Your Ref: OWPC17766
Our Ref: FG/202/17/PL 15-12-2017
Please ask for:
Ross Leal

Change of use from restaurant (A3 Restaurant) to takeaway (A5 Hot Food Takeaway),
repositioning of extraction flue, removal of existing rear extensions, erection of rear
extension for 1 No. flat.

104 Ferring Street Ferring

Proposed Roof Plan

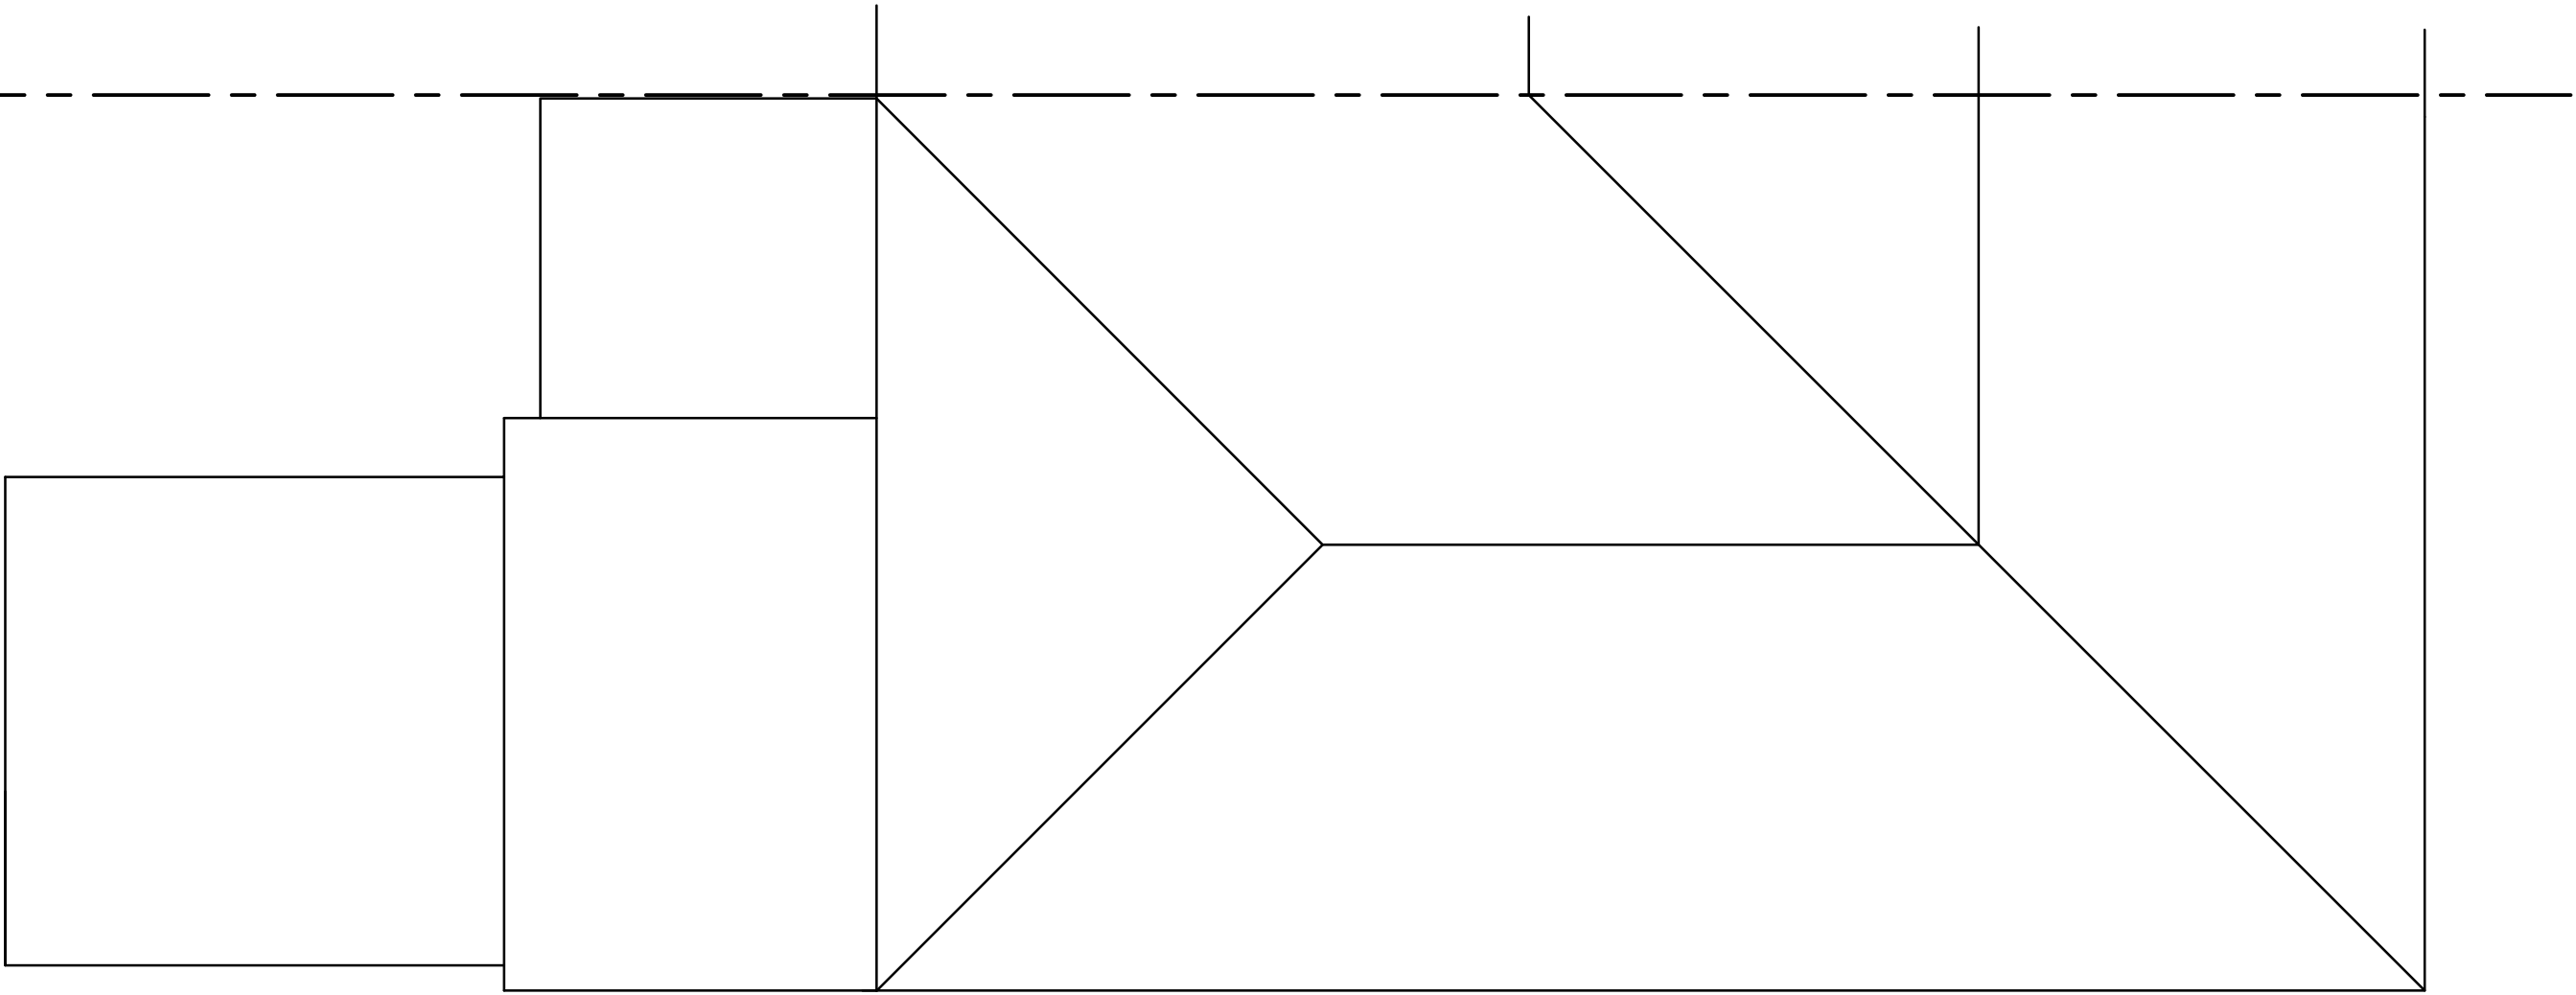
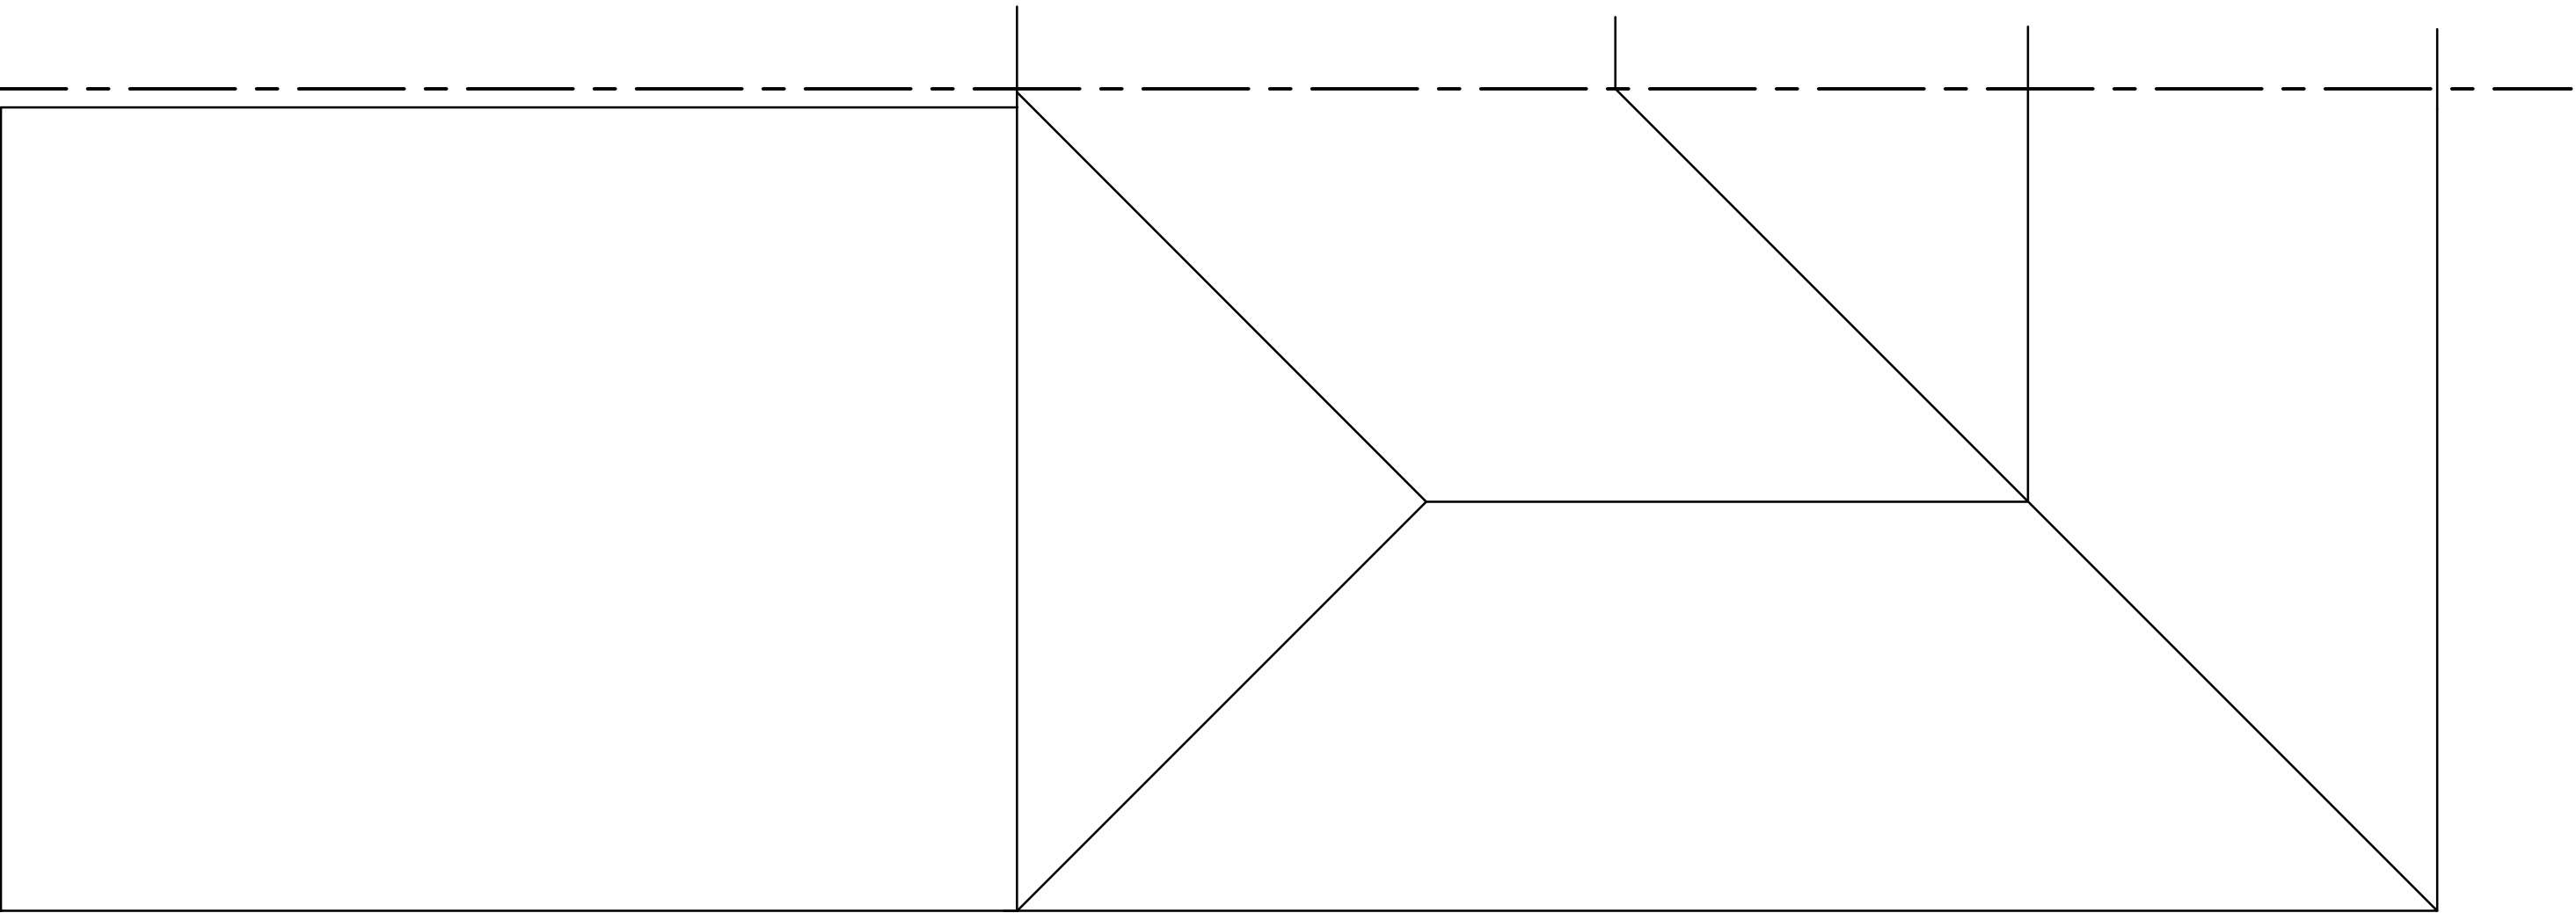
*MY ONLY CONCERN IS THE DIAMETER OF THE PROPOSED NEW EXTRACTION
FLU. THE ORIGINAL FLUE SIZE IS NOT TRUE TO SCALE AND LOCATION ON THE
APPLICATION DRAWING. AS LONG AS IT IS IN KEEPING WITHIN THE DOMESTIC
STYLE THEN I HAVE NO OBJECTIONS.*
